From: James Thompson [REDACTED]
Sent: 31 October 2019 12:16
To: Daun Johnson <Daun.Johnson@arun.gov.uk>
Cc: Adam King [REDACTED]
Subject: RE: A/146/19/PL - Revised Planning Drawing

From: James Thompson [REDACTED]
Sent: 25 October 2019 15:14
To: Planning <Planning@arun.gov.uk>
Cc: Adam King [REDACTED]
Subject: A/146/19/PL - Revised Planning Drawing

Further to our telephone conversation please see attached the revised planning drawing for the purposes of validating the application for Land rear of 1 The Heathers, Arundel Road, Angmering.

P3	25.10.19	Revised notation.	JT	AK
P2	25.10.19	Revised red line and road name correction.	JT	AK
P1	17.10.19	Planning Issue.	JT	AK
Rev	Date	Revision Details	Dr	Ch

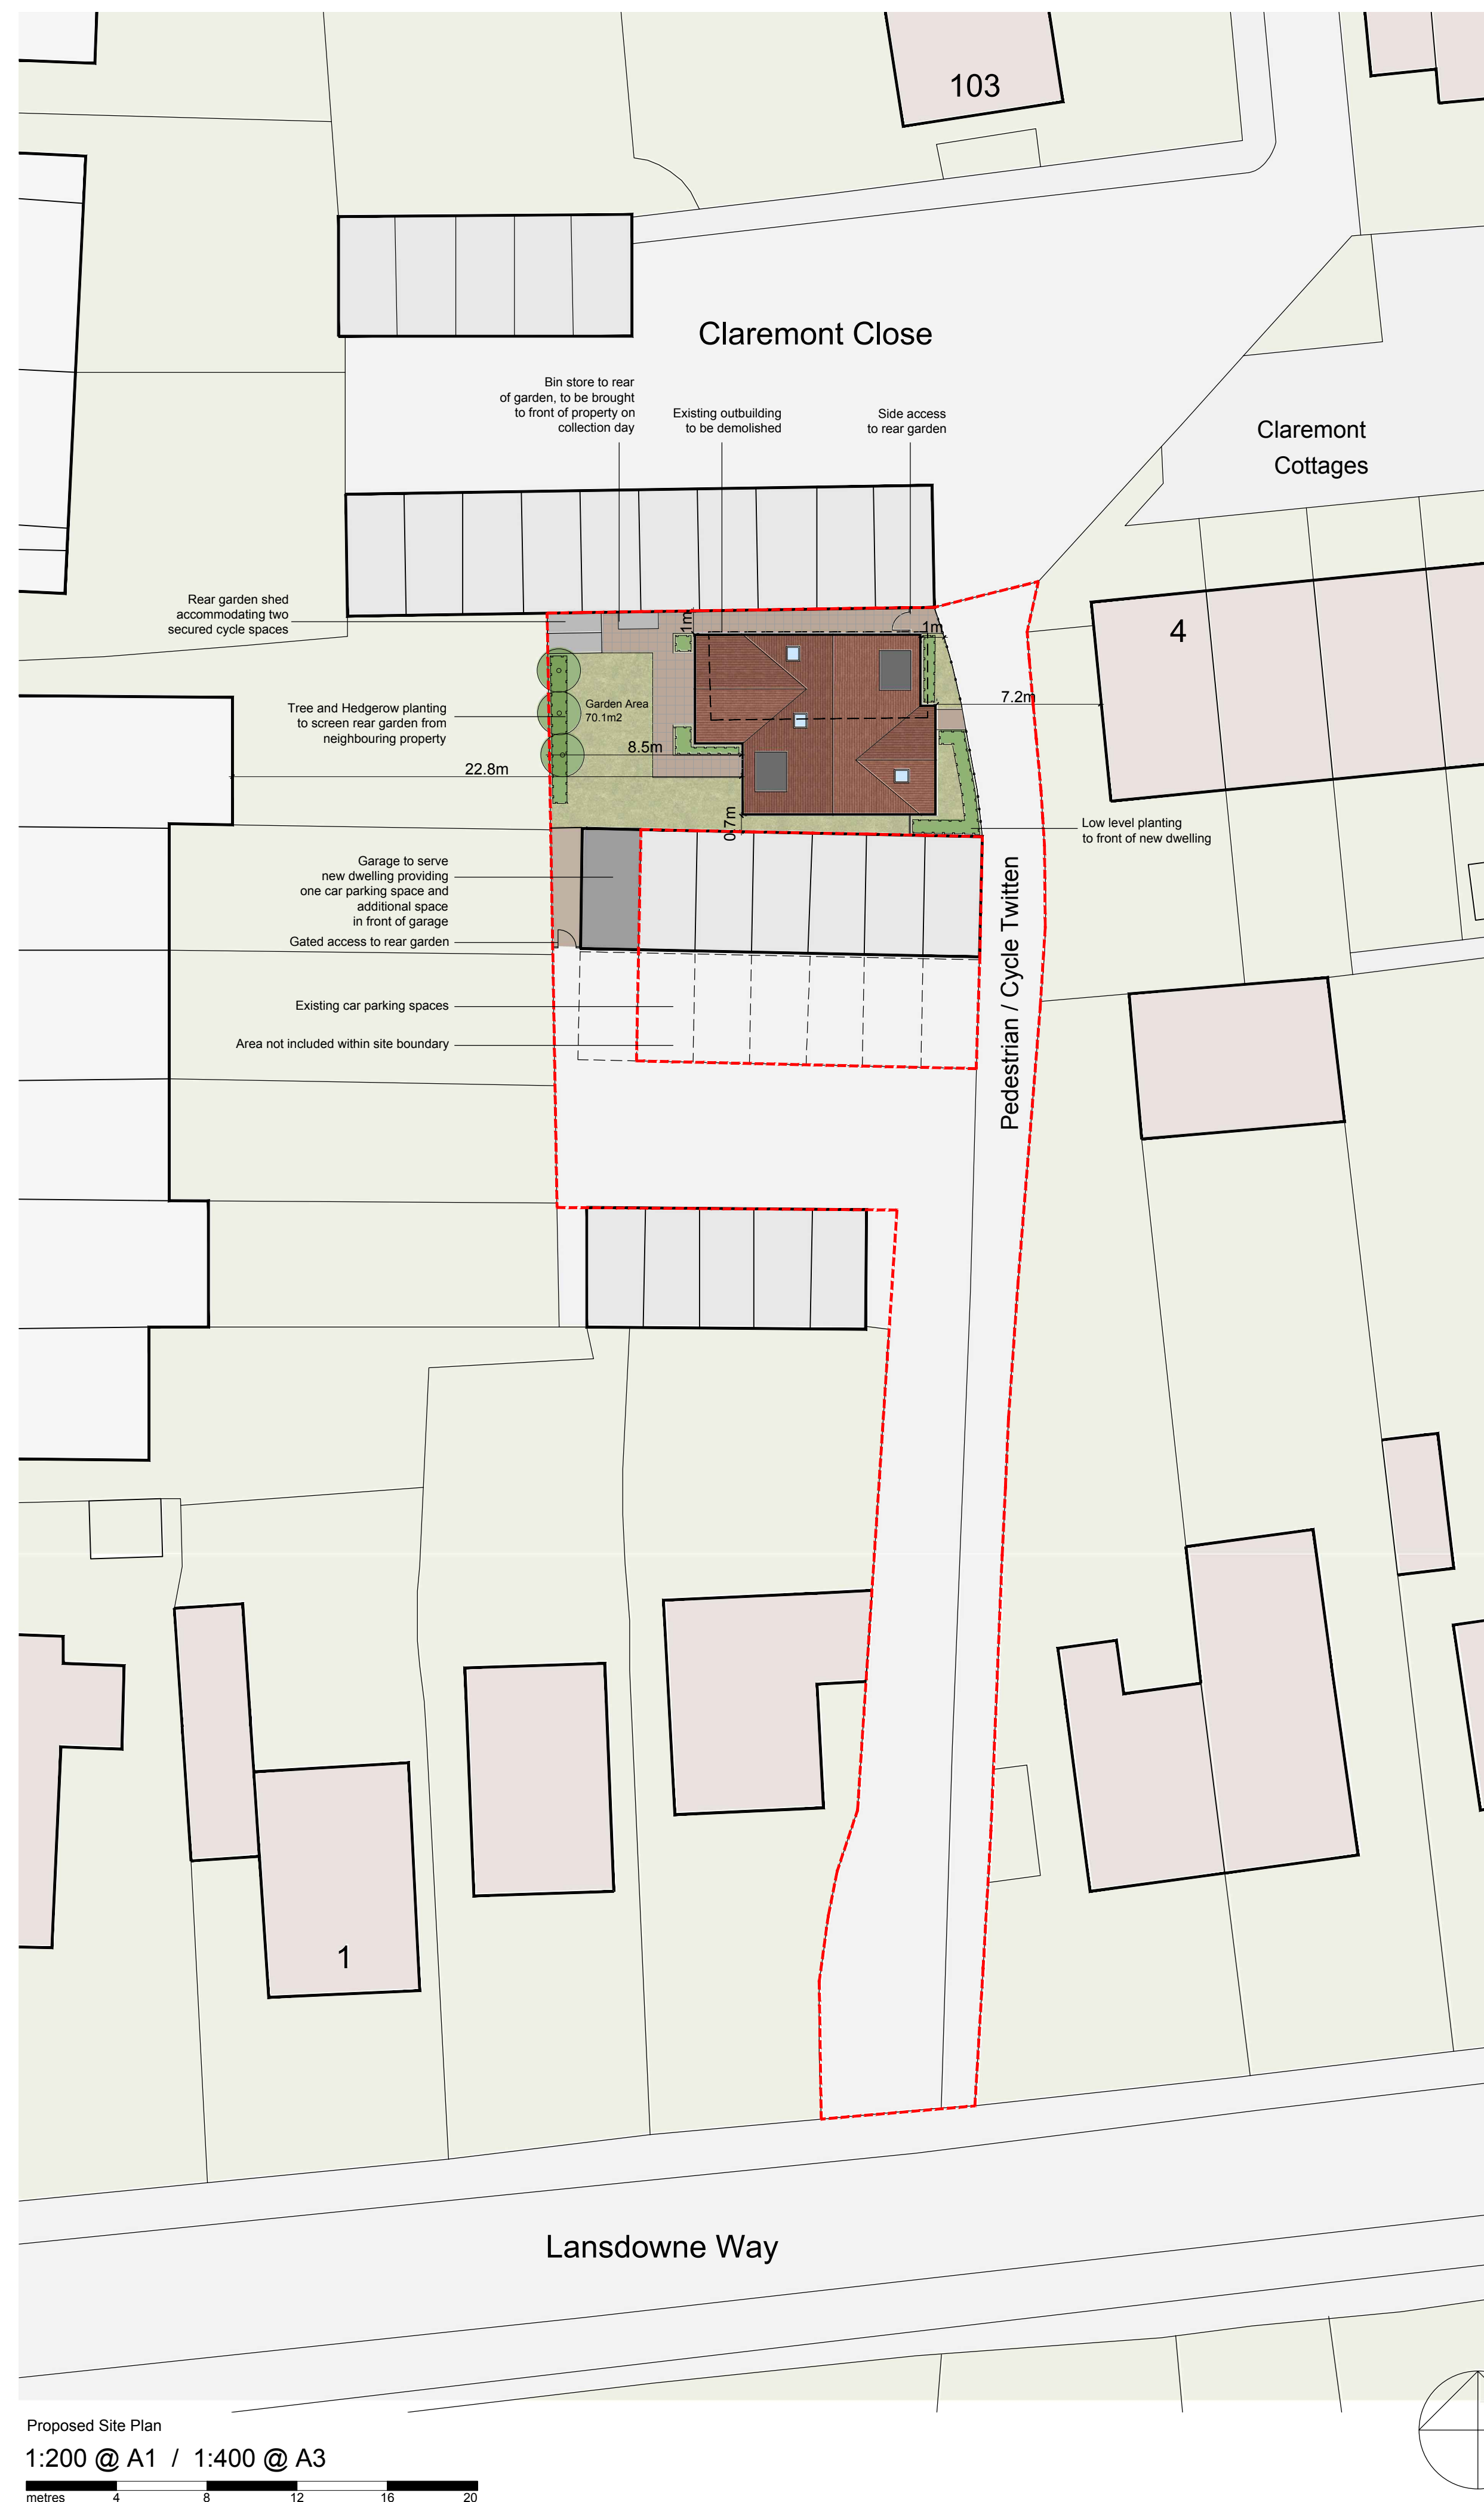
On the location, block and site plans, please annotate the garages, where you have added the red edge around, that the space does not form part of the application.

Also, on the original plans the garage south west of the site was to be used by the applicants but on the new plans, the garage is not within the red edge. Please confirm if the garage is to be in the red edge as the original plans showed because in the DAS, it is stated that '...one of which will be utilised to serve the new dwelling'.

Further to our conversation on Friday, the garages have been annotated in the updated drawing attached which as discussed over the phone addresses the first and final point of your email below.
